Ms Marian Higgins
Planning Approvals Manager NSW & ACT
Holcim (Australia) Pty Ltd
Northpoint Tower
Level 40 100 Miller Street
North Sydney 2060 NSW

20/11/2024

Subject: Survey plan for approved Limits of extraction – Schedule 2, Condition 23

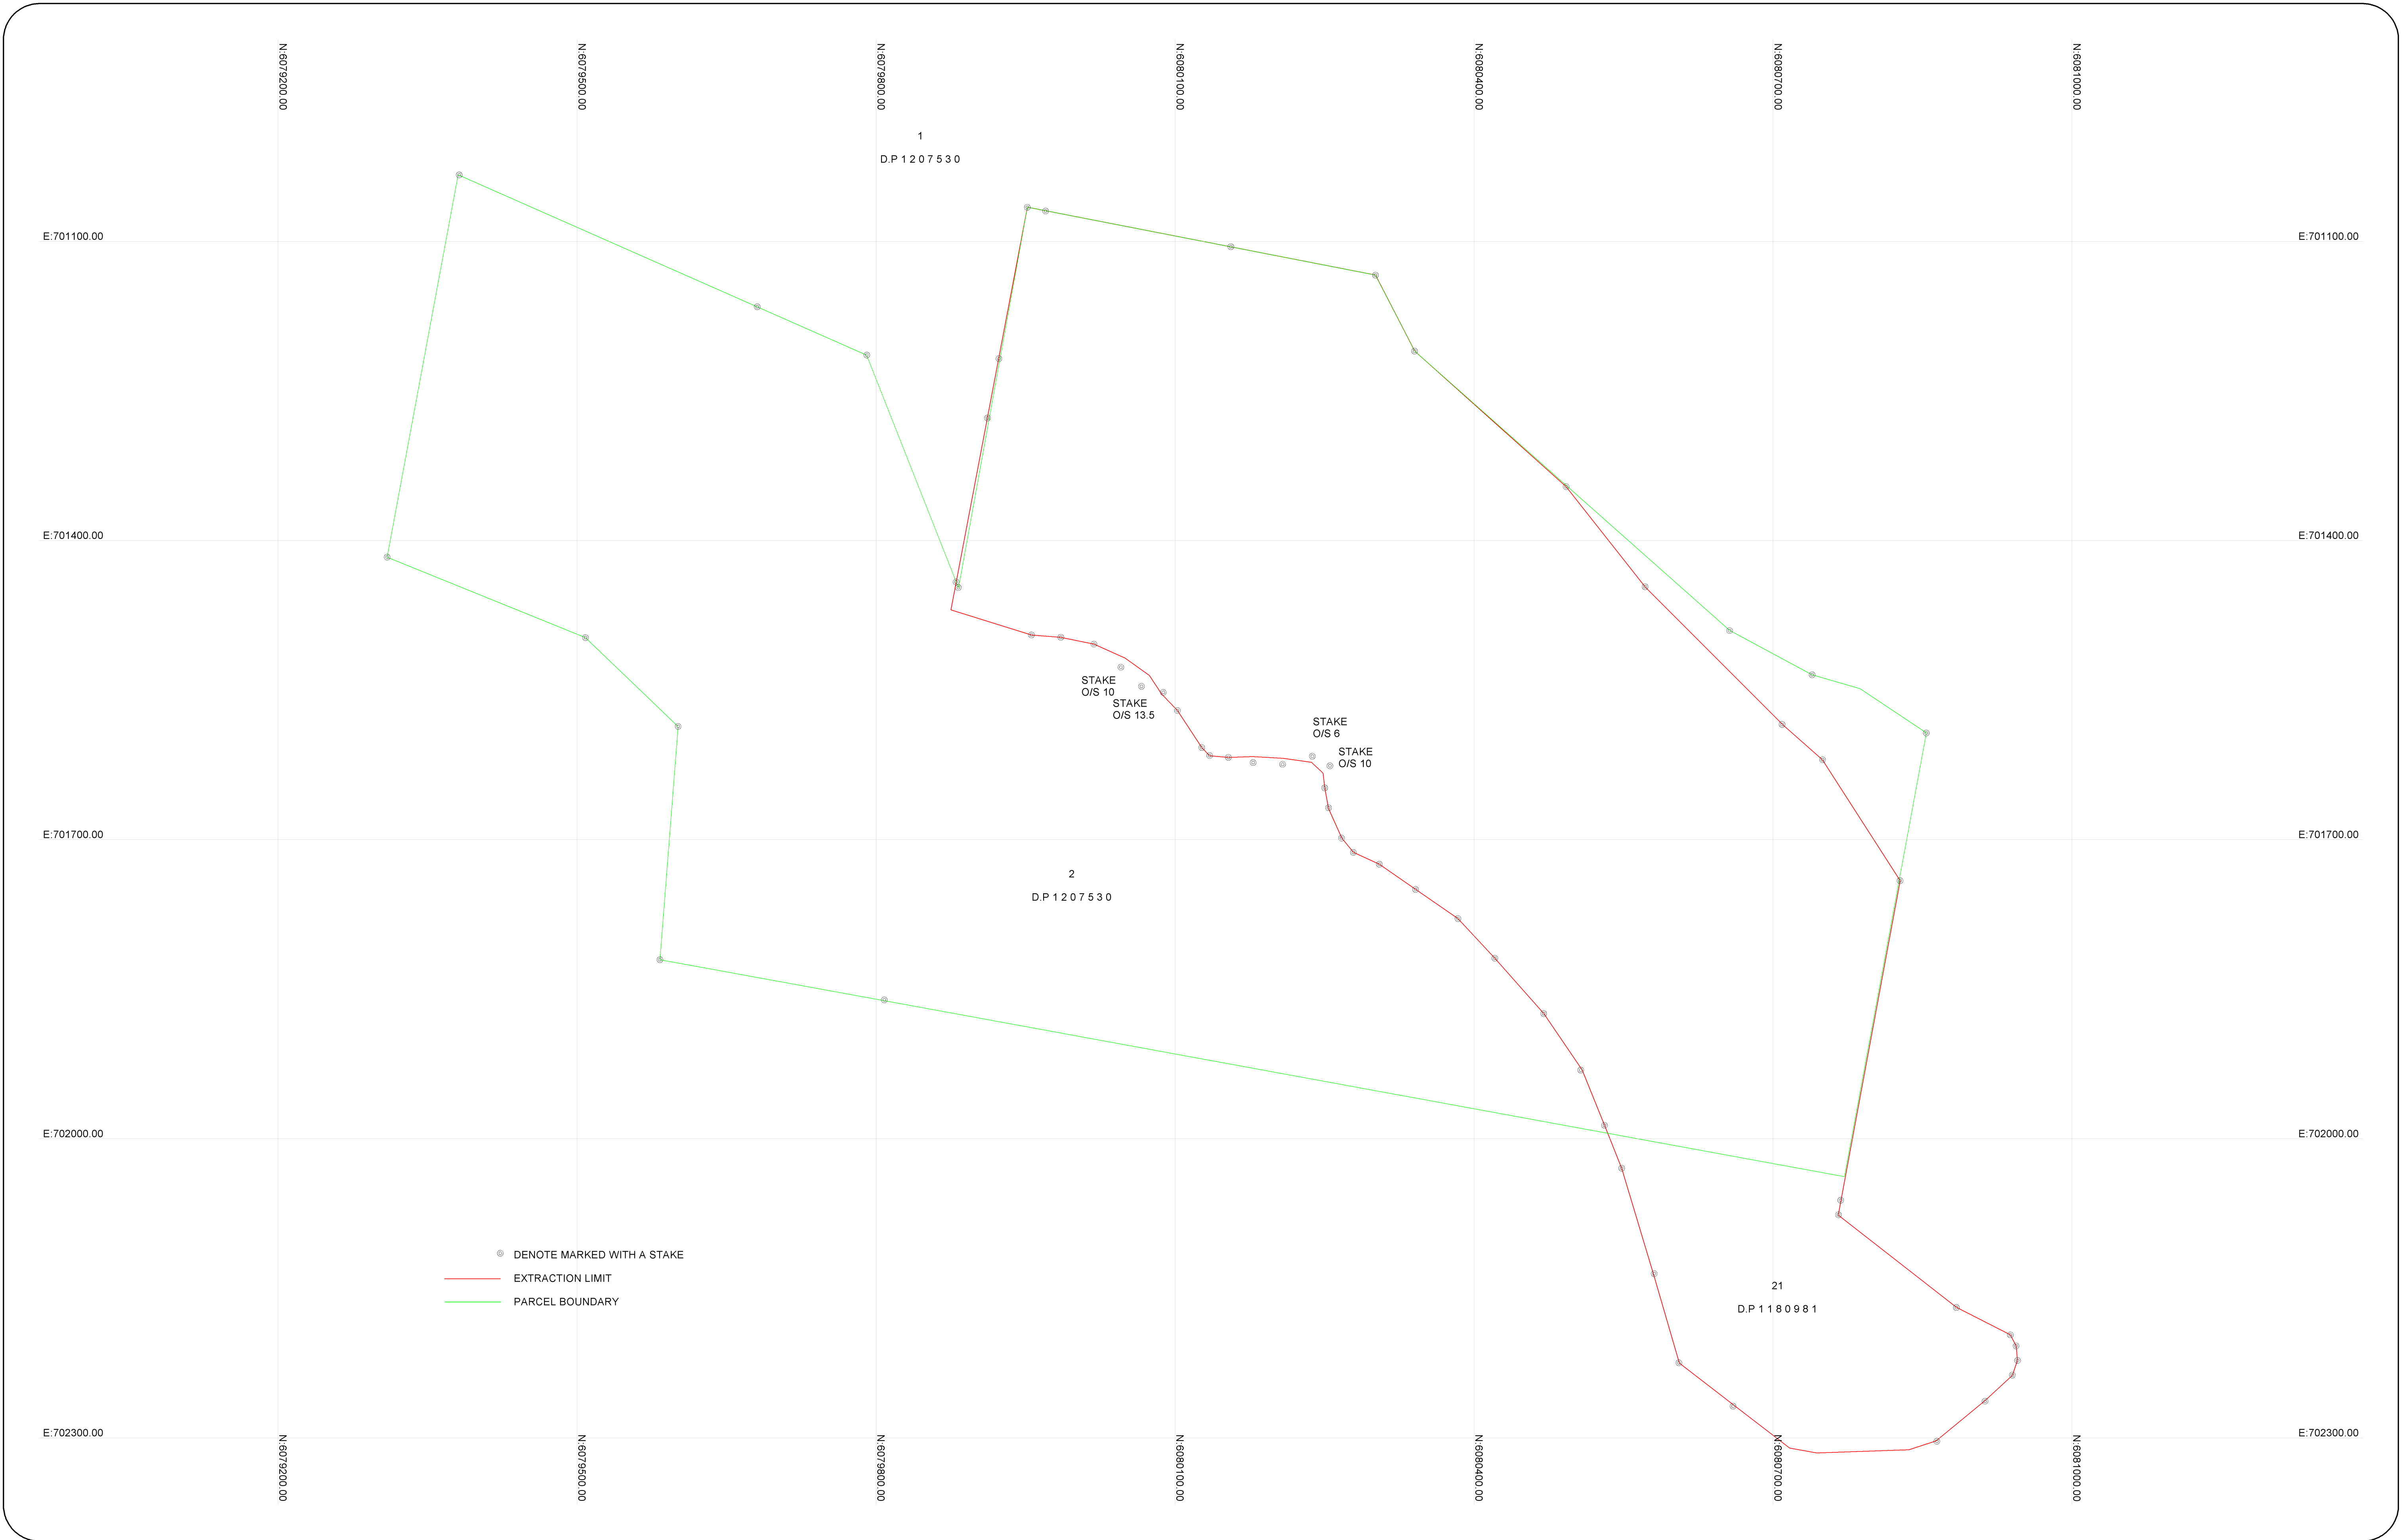
Further the survey plan submitted provides no clarity on where the extraction limit is in relation to the land to which the development consent applies, or the originally approved development footprint described in the relevant environmental impact statement or modification application reports.

Consequently, you are requested to lodge a modification application to ensure the development consent accurately applies to land relevant to the quarrying operations, and to clarify the surveyed extraction limit against the approved extraction limits.
